**Subject: MISC/259/2018 - Nsw Department Of Planning And Environment –  
Submission For Mandalong Southern Extension Project - Modification 6**

Council has reviewed Modification 6 to Development Consent SSD-5144 to include controlled release of stored water from the sediment dam at Manalong South Surface Site and transport sediment and material collected at the Mandalong Surface Site to the Cooranbong Entry Site.

Figure 2 | MSSS site layout

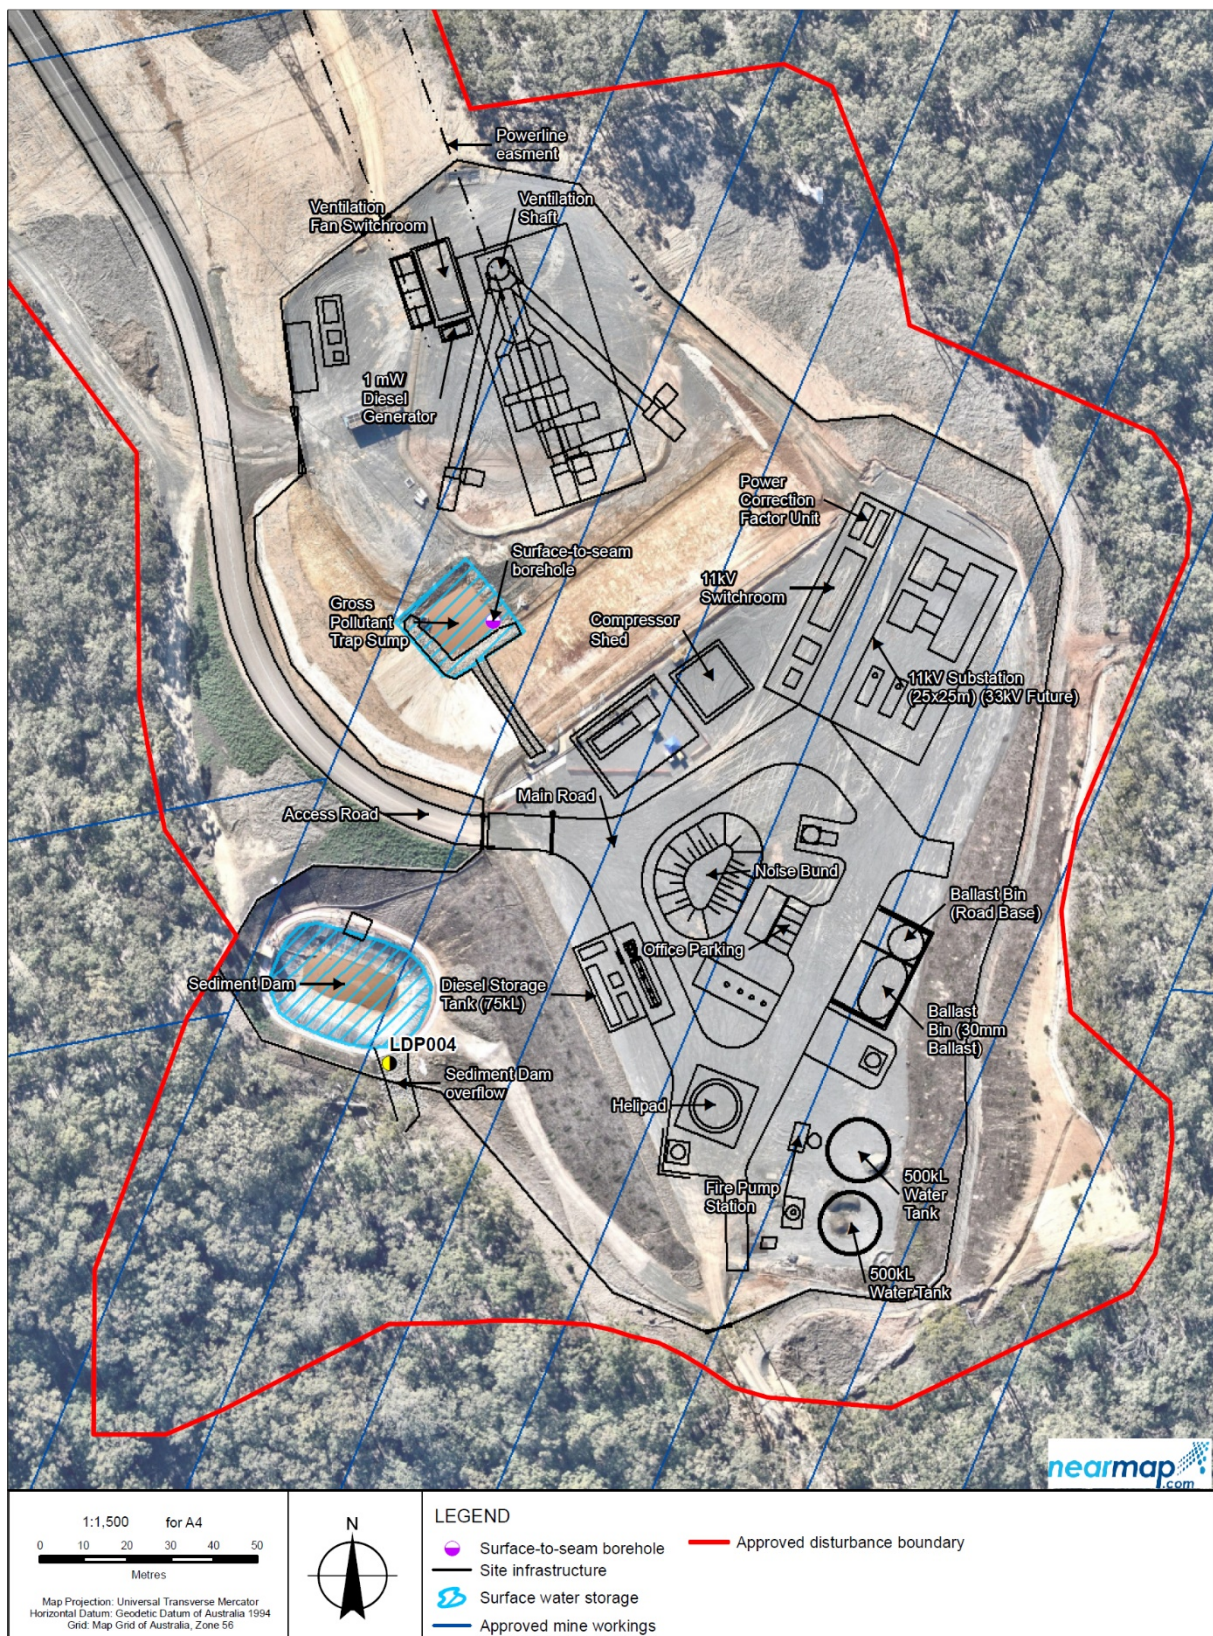
Council notes that the site falls within the Gorokan Soil Landscape which exhibits soils with a very high erosion hazard. Given these soil conditions, Council recommends alternative solutions which respond to the soil characteristics be implemented. These alternative solutions include:

- Reducing the sediment load of water entering the basin by utilising chemicals and other sediment control methods to stabilise the soils, and
- Changing the design of the basin to operate as a continuous flow basin in accordance with the revised Appendix B Sediment Basin Design of the *Best Practice Erosion and Sediment Control* (International Erosion Control Association of Australasia 2018).
